From: Simon Davis <Simon.Davis@arun.gov.uk>
Sent: 17 December 2021 15:48
To: Planning.Responses <Planning.Responses@arun.gov.uk>
Subject: FW: Planning Consultation on: Y/163/21/DOC Land at Street Buildings

Further Drainage Comments.

Proposed Drainage Design Layout Sheets

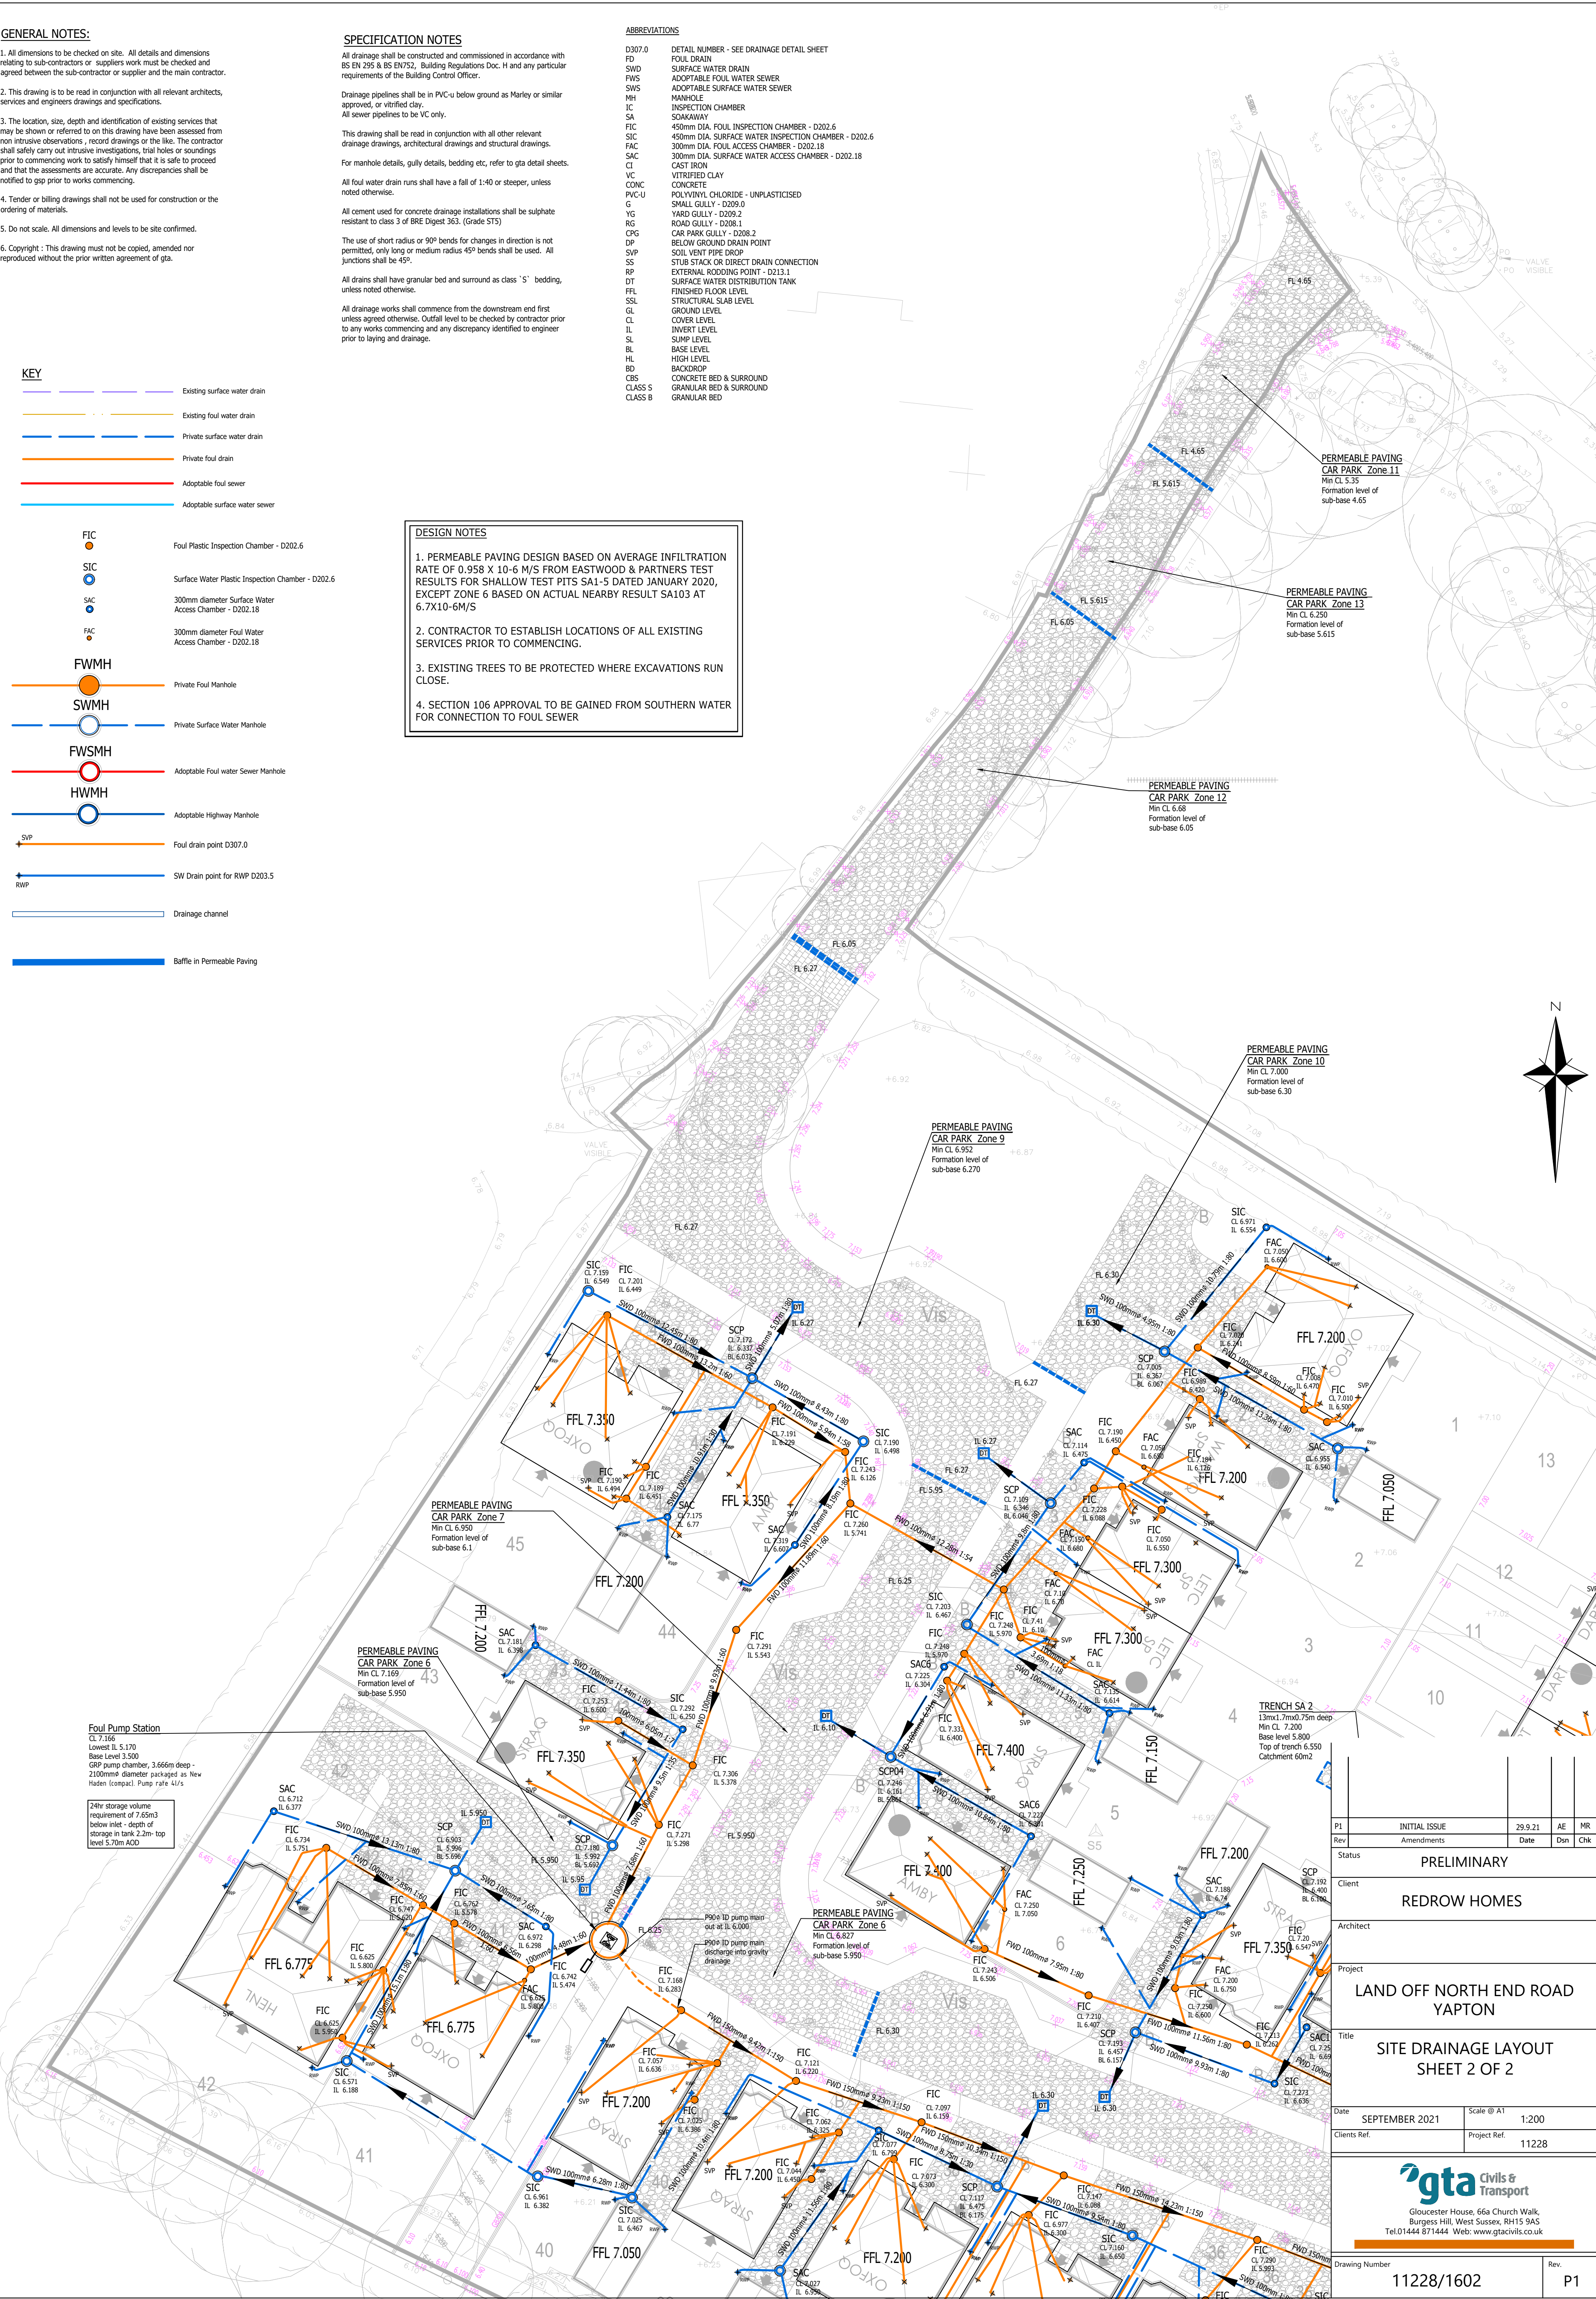
The drainage layout is included in the Foul & SuDS Drainage Statement & Maintenance Plan but I note that a previous comment relating to an infiltration blanket for Zone 9 is not addressed. I would also suggest that the document contains a lot of information that is not relevant to ongoing maintenance; it would therefore benefit from
